**Kent Road Public School Redevelopment, 126 Kent Road, Marsfield (SSD 9344)
Notice of Exhibition**

TAB A – Detailed comments on SSD 9273

Figure 31 Existing and proposed set down / pick up arrangements

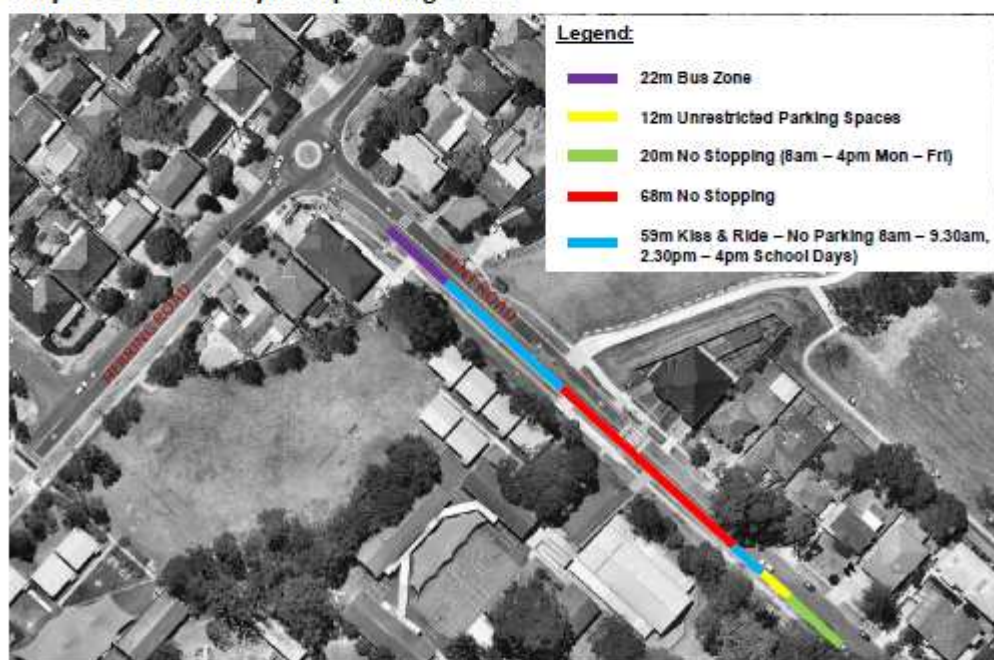
- There is an existing 'kiss-and-ride' facility for 8 parking spaces along Kent Road
- The turnover rate of 1 parking space in this facility assumed to be 150 seconds (120 second parking duration with 30 seconds to allow for vehicle changeover)
- Subsequent service capacity of 192 vehicles per hour, which can be calculated as follows:
 - $\text{Service capacity} = \frac{8 \text{ (number of spaces)} \times 3600 \text{ (seconds in an hour)}}{150 \text{ seconds (sec/veh)}}$

It should be noted that the above assumes that arrivals occur uniformly over the hour prior to school start. This assumption should be verified. Previous assessments, such as the one undertaken for the Alexandria Park Community School, have found that the majority of drop-off and pick-up movements occur shortly before and shortly after school.

However, it should be recognised that parents/guardians have preferences as to how pick-up/drop-off is undertaken and that not all trips would use the 'kiss-and-ride' facility.

DP&E should note the above when considering the merits of the findings of the traffic assessment supplied with the application.
